7.16.19 Planning Div. Comments on MMC Sound Management Plan (rev 6/19/2019)

The City engaged a Peer Reviewer (Principal Consultant at HMMH) to review the submitted *Plan*. The Peer Review comments were given to MMC in March, 2019 and the city requested that the *Plan* be revised to address the Peer Review concerns. The current revised *Plan* was received June 19, 2019 and our review has concluded that it does not address all of the Peer Review comments nor all of the city's specific requests as set out in e-mails dated 11/14/18 and 3/19/19. The comments below summarize the key outstanding issues.

Figure 1 - Mean Measured DNL, Summer 2018

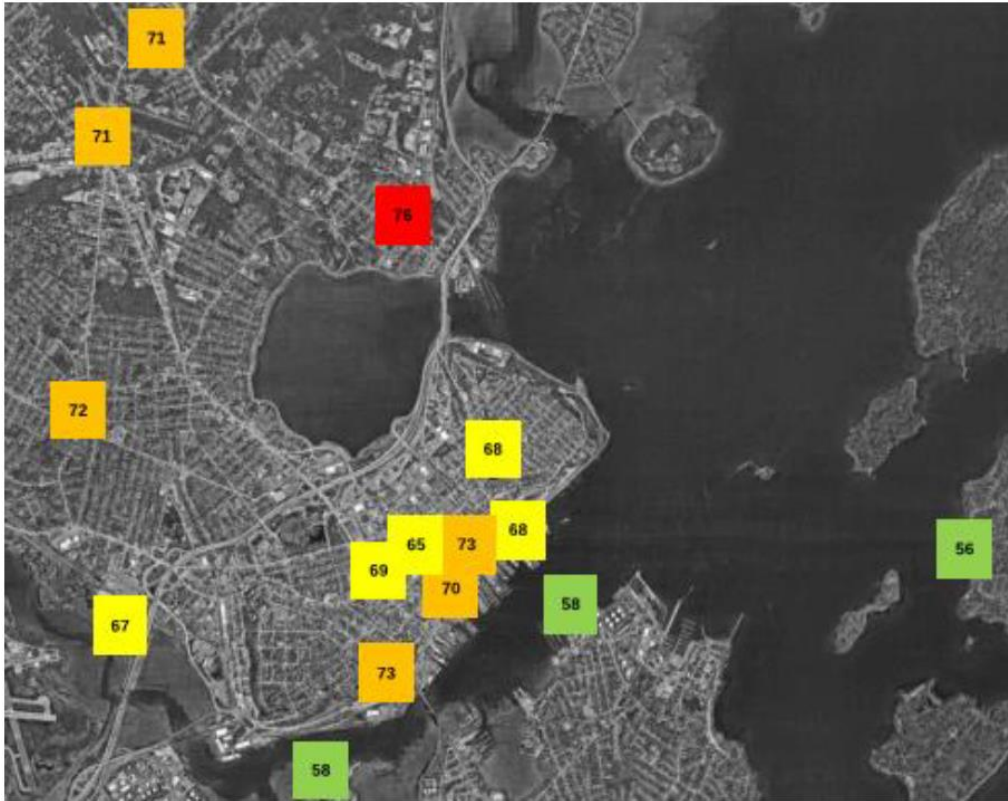
2. Standards of Aircraft Sound: The Peer Reviewer recommended that in the absence of local standards for this unique issue, that the FAA standards regarding environmental impact of helicopter/aircraft sound impacts should be used. The revised *Plan* refers to this but does not quote the standard (relevant to compatibility with residential land use) in full nor include the reference to a 1.5 DNL increase if it brings the level over 65 DNL. Also, it does not provide a summary of the current and predicted (for new location) DNL levels related to the measuring points (see below) in order to see whether the predicted sound levels associated with the relocated and more frequent flights are below or above the FAA standard.

Fig.4.5 Proposed Flight Routes for the new MMC Helipad

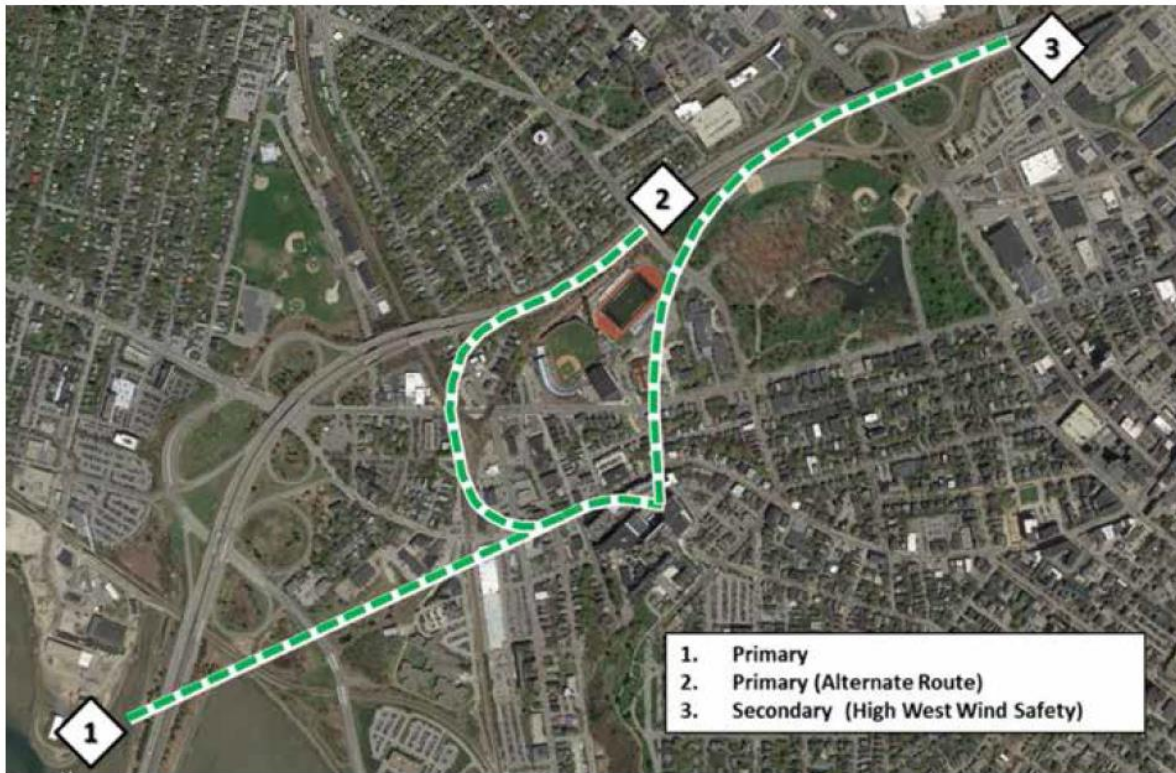
9. Monitoring and triggers for assessing implications of any changes: There are anecdotal observations that helicopters are currently using different flight paths from those confirmed in the IDP, and are operating at a greater frequency than has been advised during the review. The *Plan* should include some mechanism for monitoring both of these flight characteristics as from the start of operations at the new helipad, as these could generate unacceptable new sound levels for the surrounding residential neighborhood, including some properties not previously affected by the helicopters using the former helipad location (see IDP for discussions regarding flight paths).

*Appendix 6: 2017 Sound Study Measurement Locations*

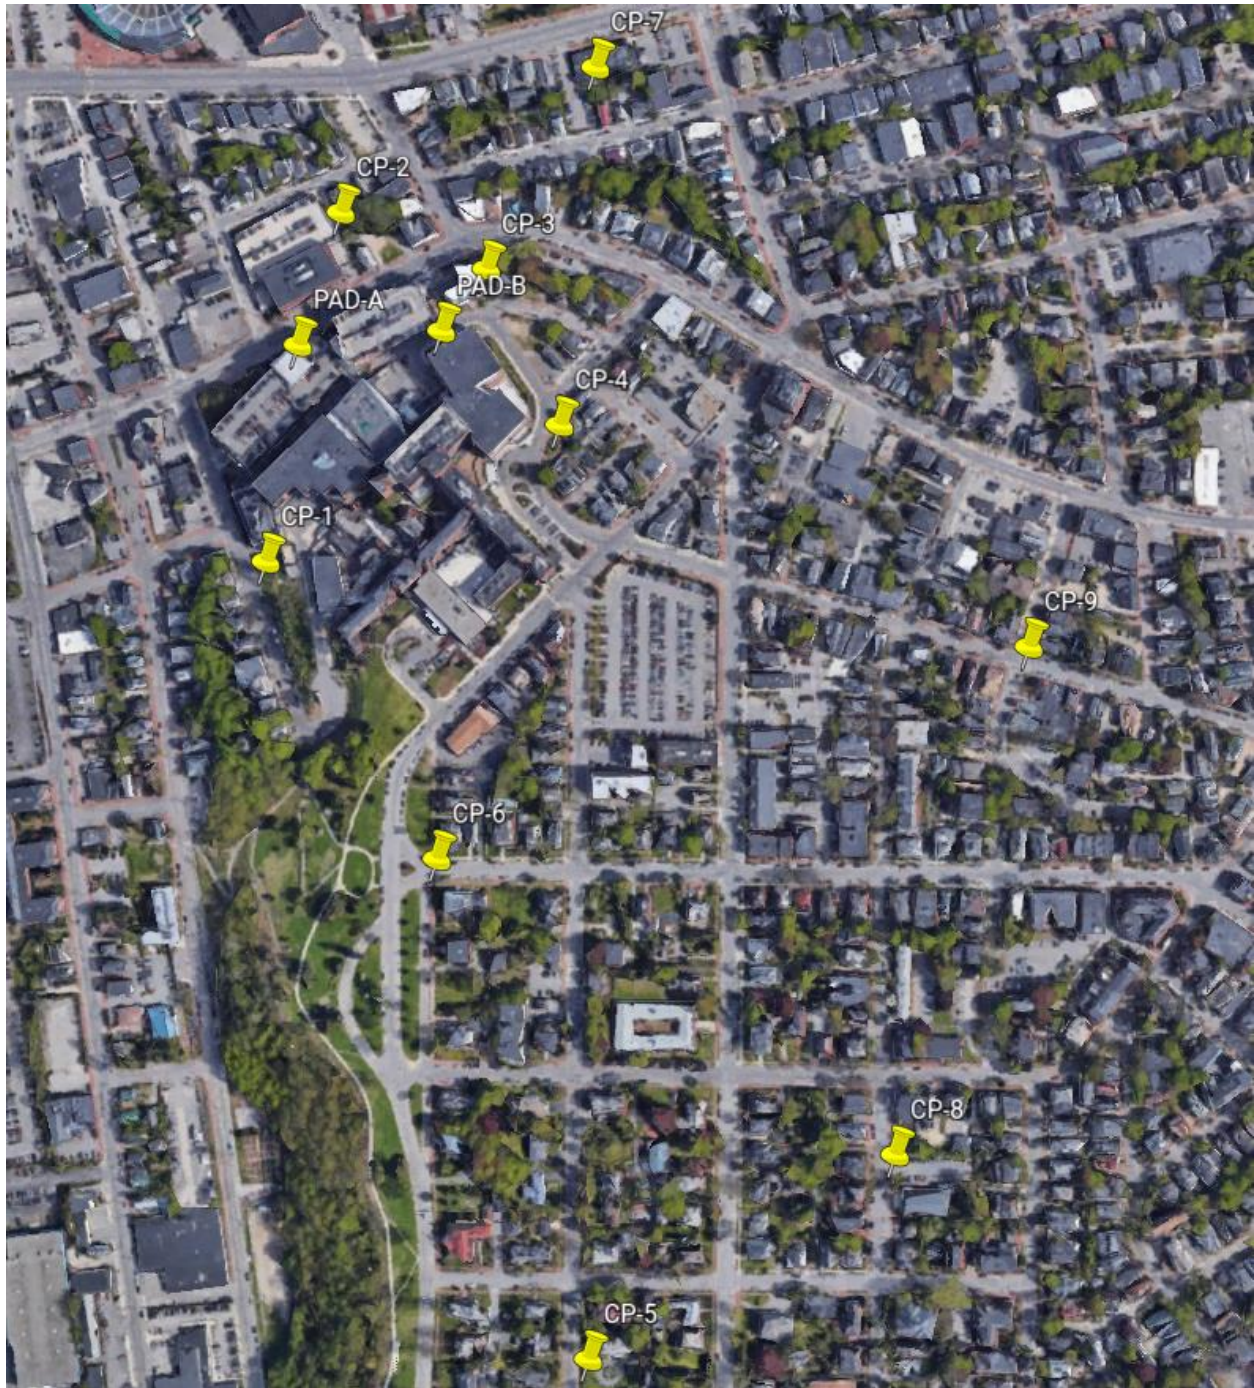
3. Location of Sound Devices - the *Plan* addresses the Peer Review suggestion to add in a tenth location but does not include the data from this location.
